From: Mau, Russell E (DOH) <Russell.Mau@DOH.WA.GOV>
Sent: Wednesday, January 29, 2025 8:23 AM
To: Bradley Gasawski
Cc: Melissa Schumaier
Subject: RE: VA-24-00003 Tinoco & Agrella - Notice of Application

The Department of Health (DOH) Office of Drinking Water (ODW) has reviewed the application and has the following official comment:

PROPOSED SITE PLAN

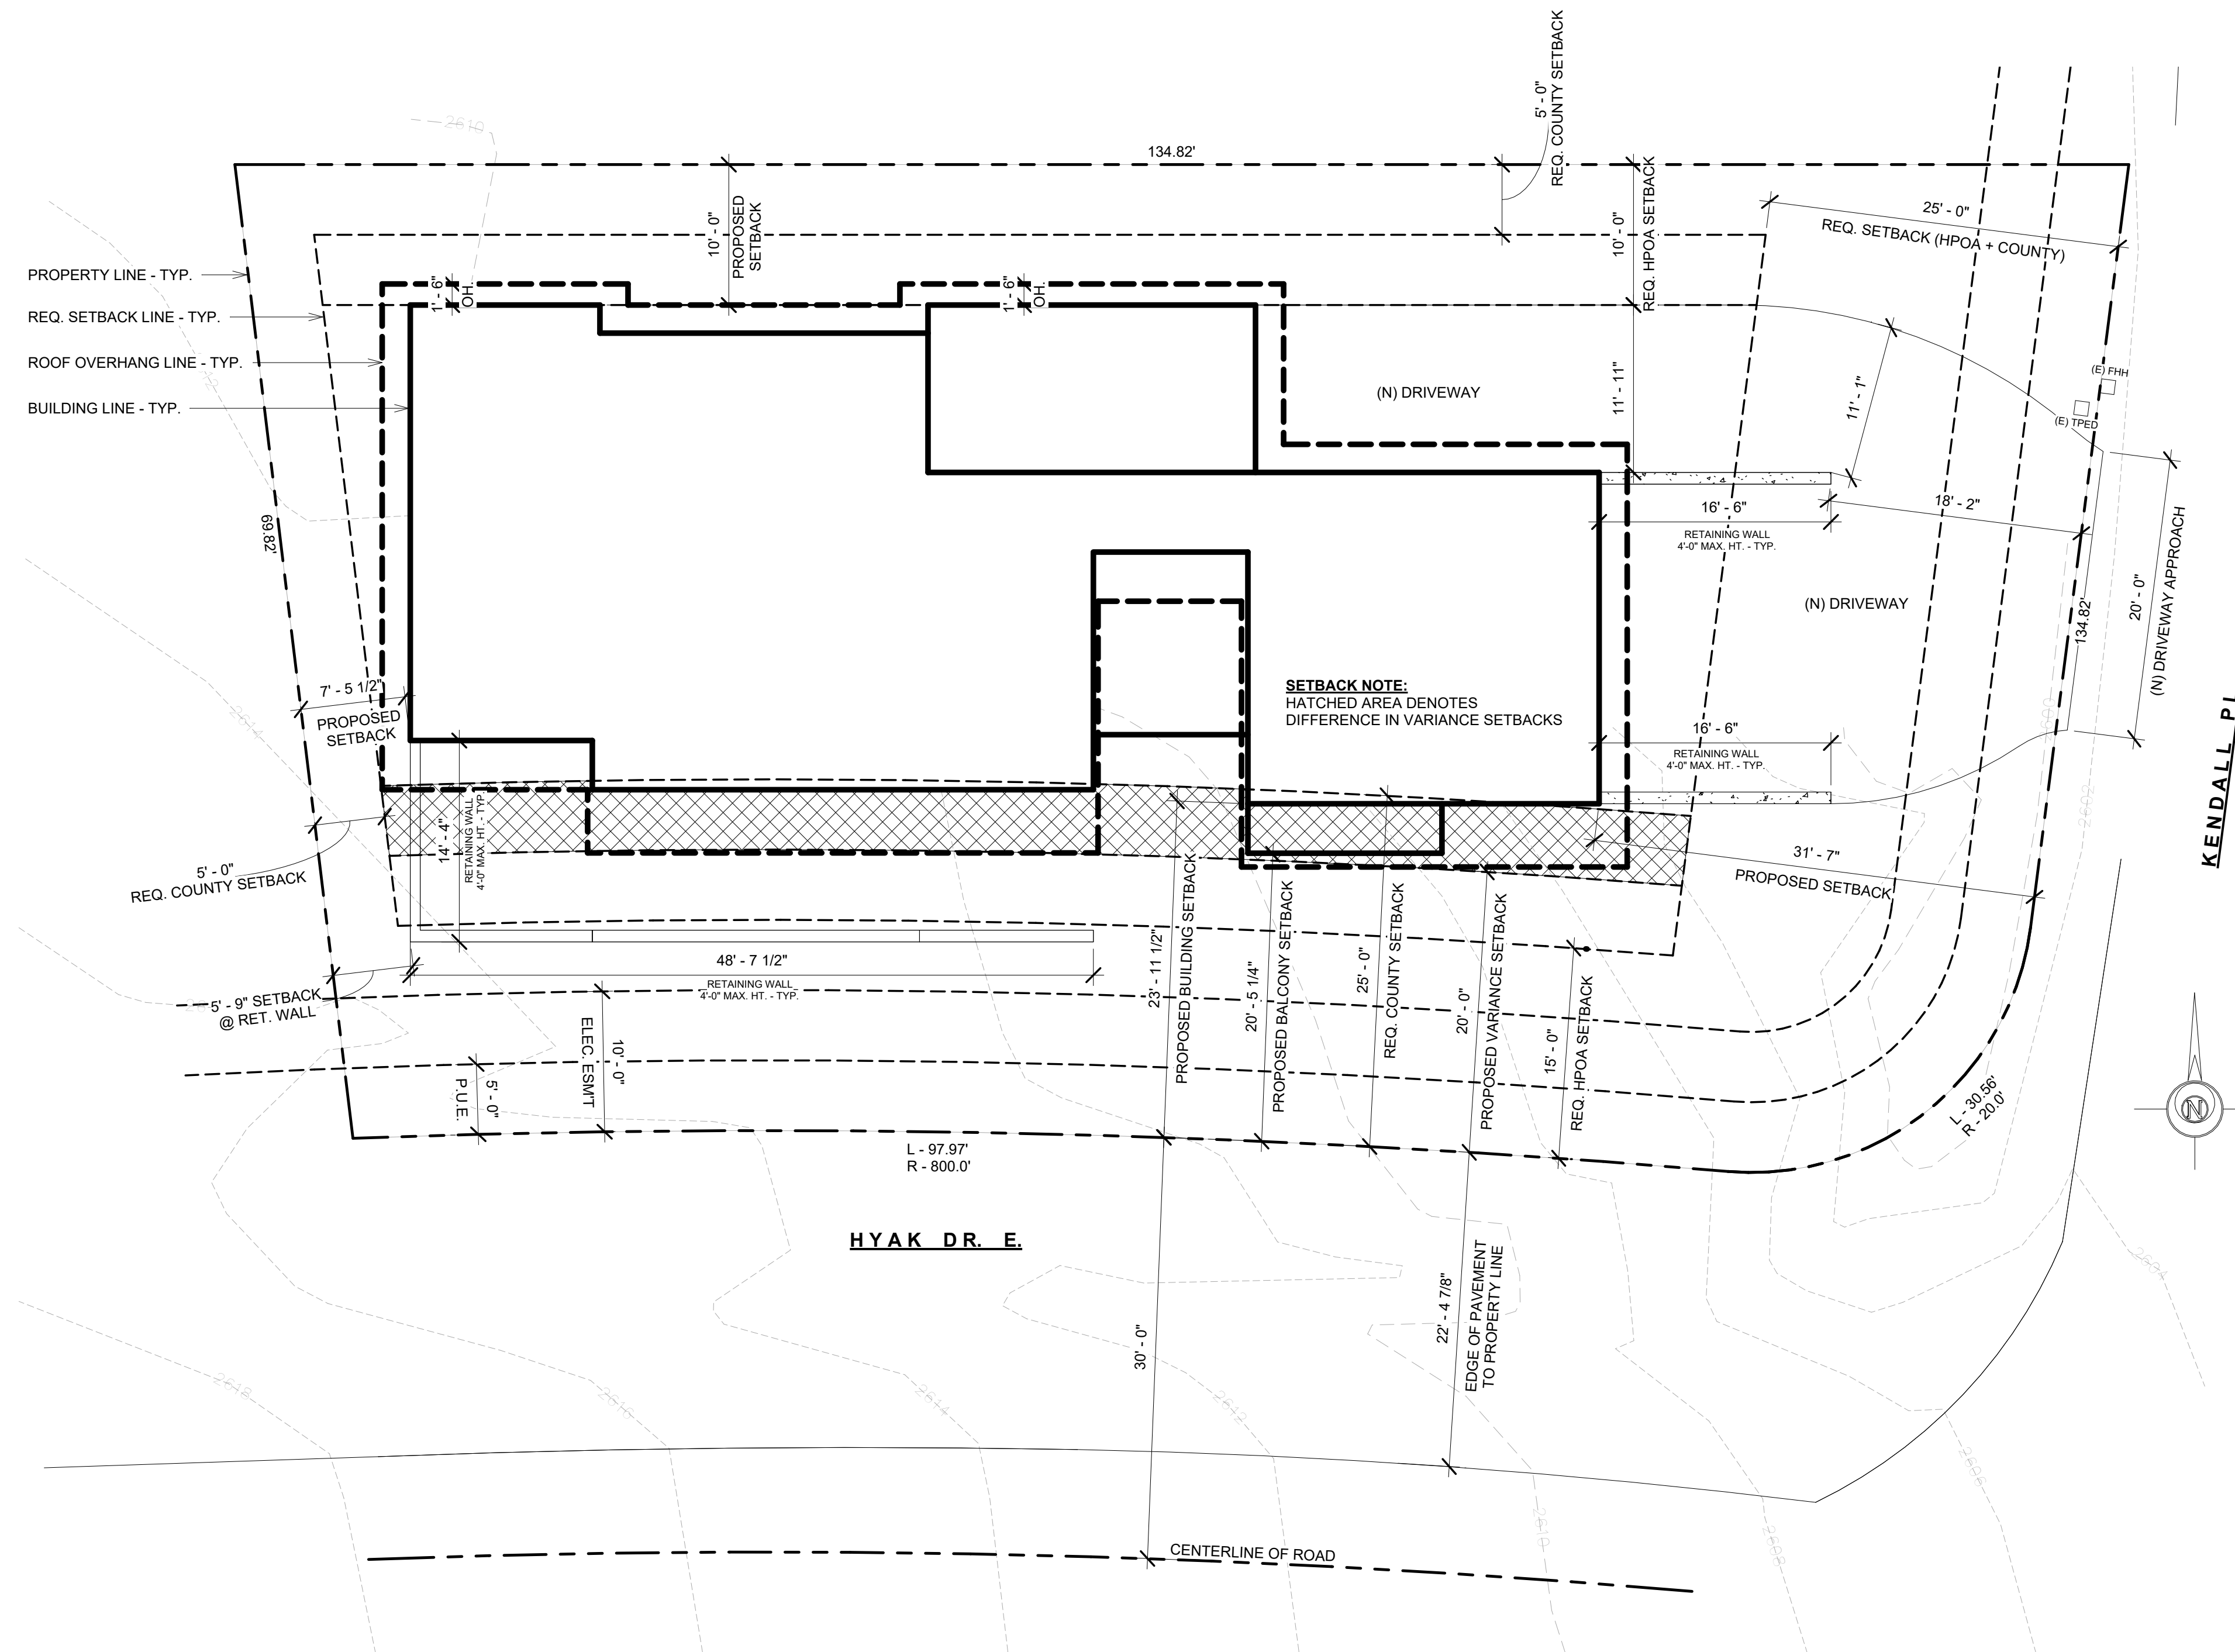
- How is drinking water being provided to this home and the second, on-site dwelling unit – private well or from a public water system?
- If the applicant's property is served by a public water system, the construction of the home and on-site dwelling unit constitutes two (2) connections, and this needs to be accounted for in the connection information (i.e., WFI) for the public water system.
